Southern Engineers, P.A.

ADDITIONAL FOOTING
(AT PILASTER)

PROJECT: LOT 150, DUNCANS CREEK
BUILDER: NEW HOME, INC

PROJECT #: 21-2816.1 (LH)-A (LOT 50)
DATE: 4-23-24
PAGE: 1 OF 1

CRAWL FND. W/ OPT. EXTENDED CAFE

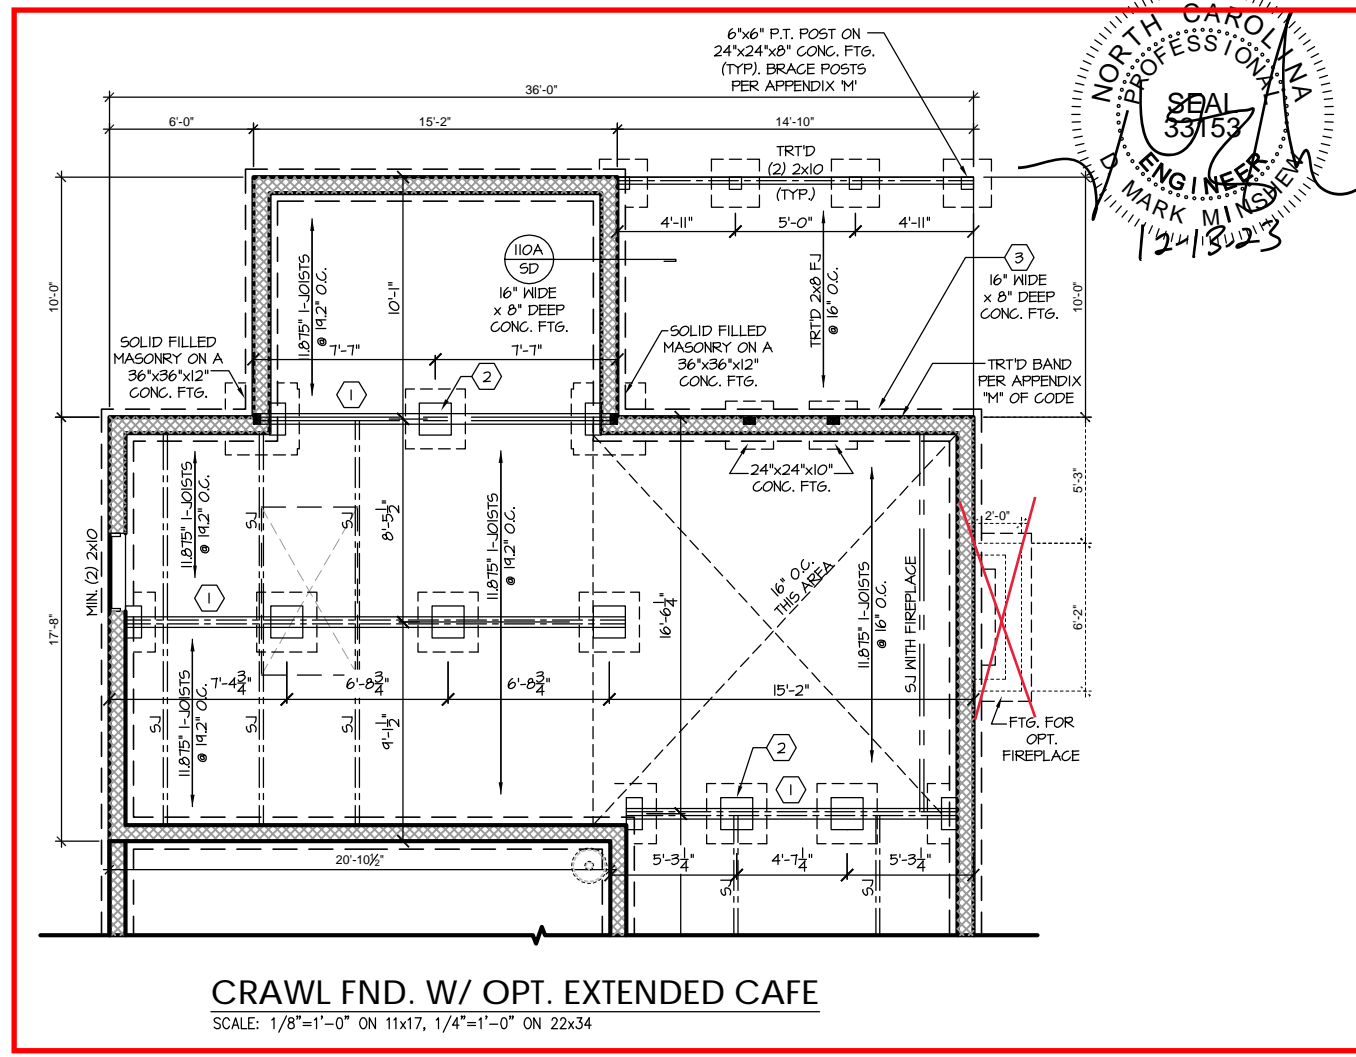
SHEET S-1.2.1 OF THE HOLLY PLAN (LH), PROJECT #: 21-2816.1-LH SEALED ON 12-13-23 SHOWS SOLID FILLED MASONRY ON A 36"X36"X12" CONCRETE FOOTING AT THE CORNER OF THE FAMILY ROOM AND EXTENDED CAFE. A 16"X16" PILASTER WAS INSTALLED INSTEAD OF THE 8"X16" SHOWN AND IS SHORT OF FOOTING PROJECTION ON THE LEFT SIDE. ADDITIONAL CONCRETE SHALL BE ADDED TO CORRECT THE PROJECTION AS SHOWN ON THE DETAIL.
